Mr Glenn Swan  
Senior Development Manager  
Huntlee Pty Limited  
1 TRITON BOULEVARD  
NORTH ROTHBURY New South Wales 2335

08/08/2019

**Modification 9 Huntlee Stage 1  
Request for Additional Information**

20406-1 TO 3000 (MOD9) - PUBLIC EMBELLISHMENTS

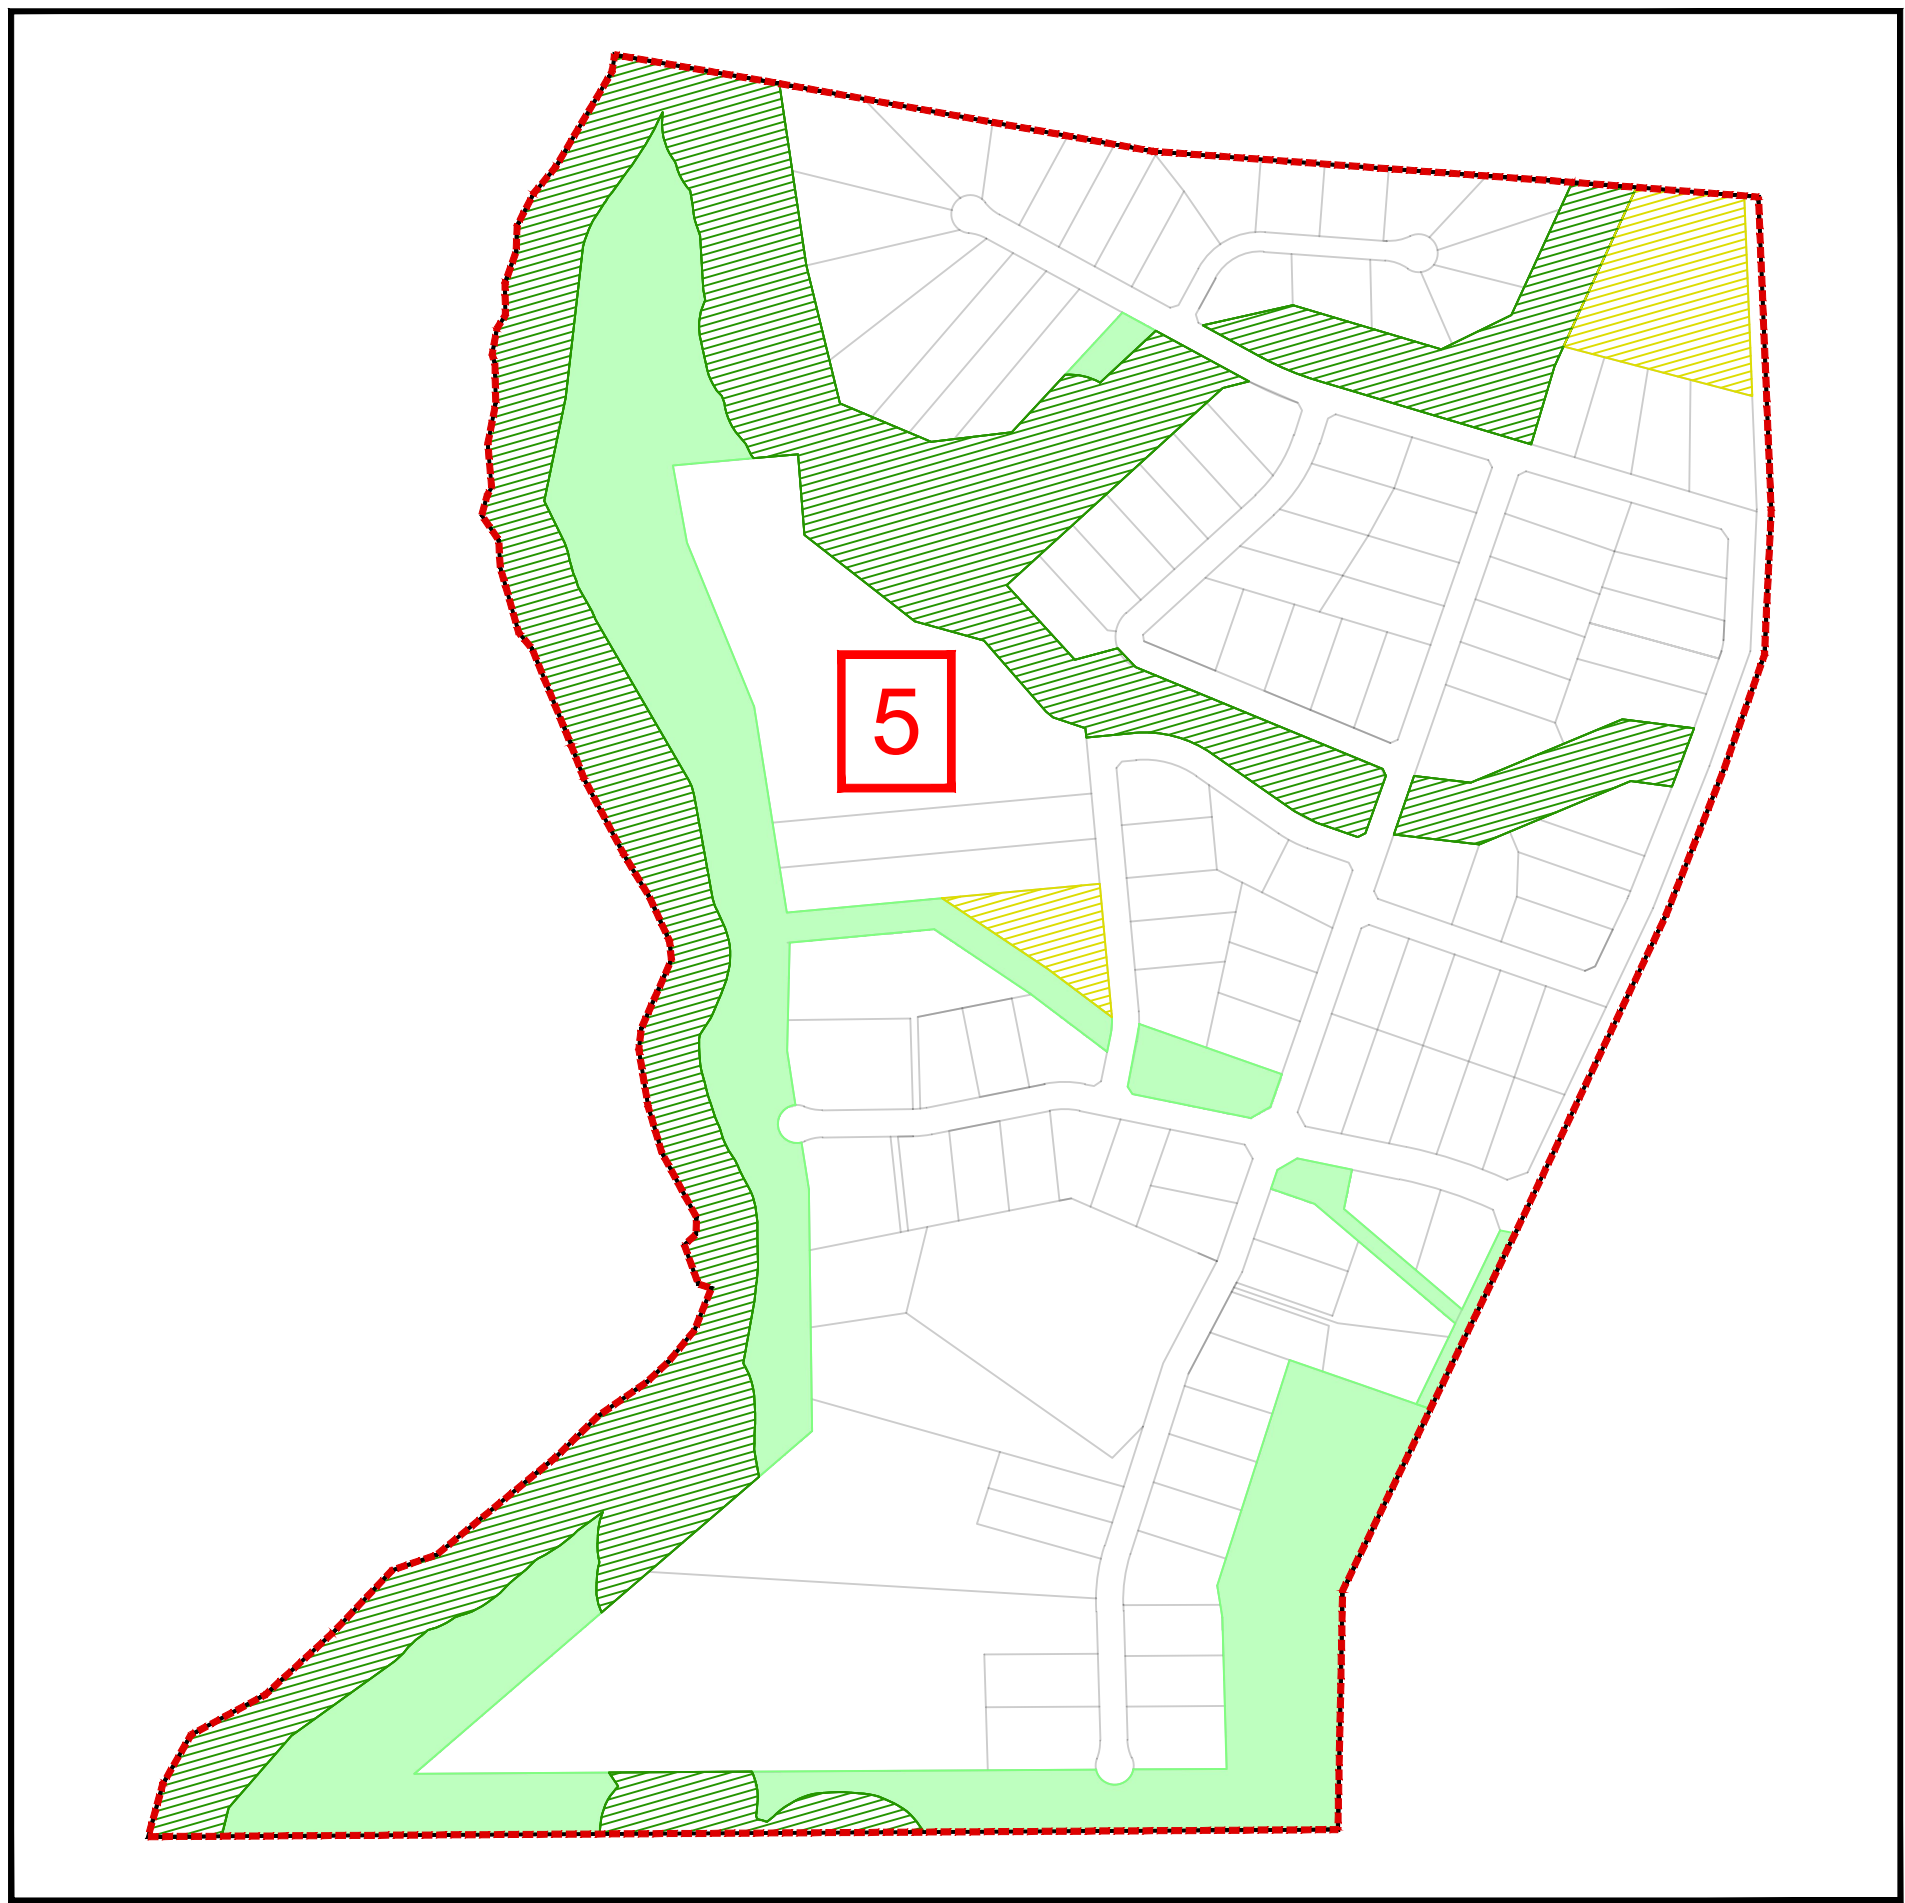
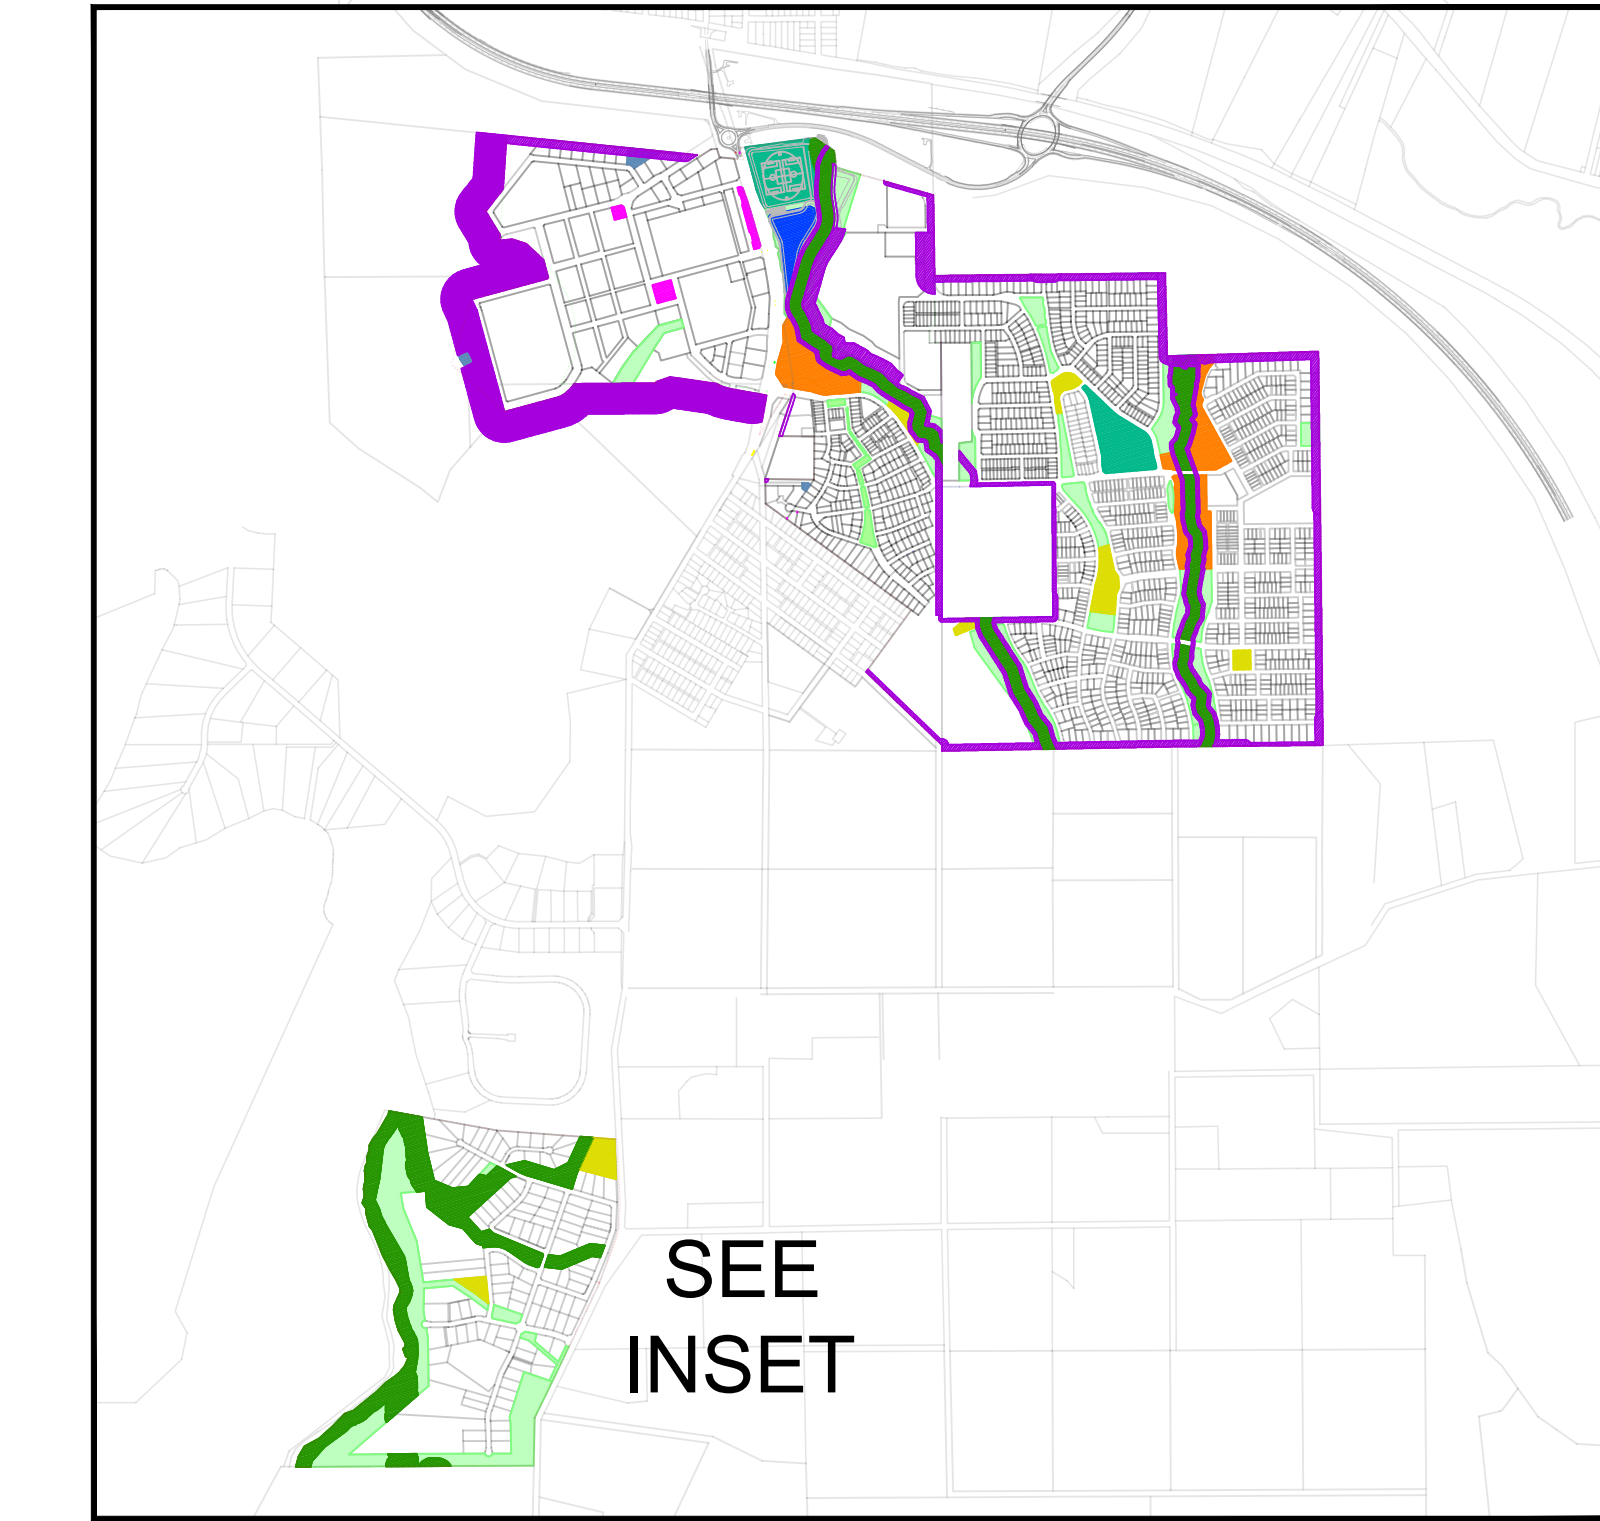
- The detention basins have been removed from the open space plan. Please show the location of these on the plans and demonstrate they will not compromise the functionality of the open spaces. The detention basins should be excluded from the usable public open space calculations.
- It is noted the park areas have been increased to reflect the local VPA commitments. However, some of the District Park areas appear to be impractical. Please provide an assessment of the changes proposed to the open space plan and ensure the park areas are appropriately located in consultation with Council.
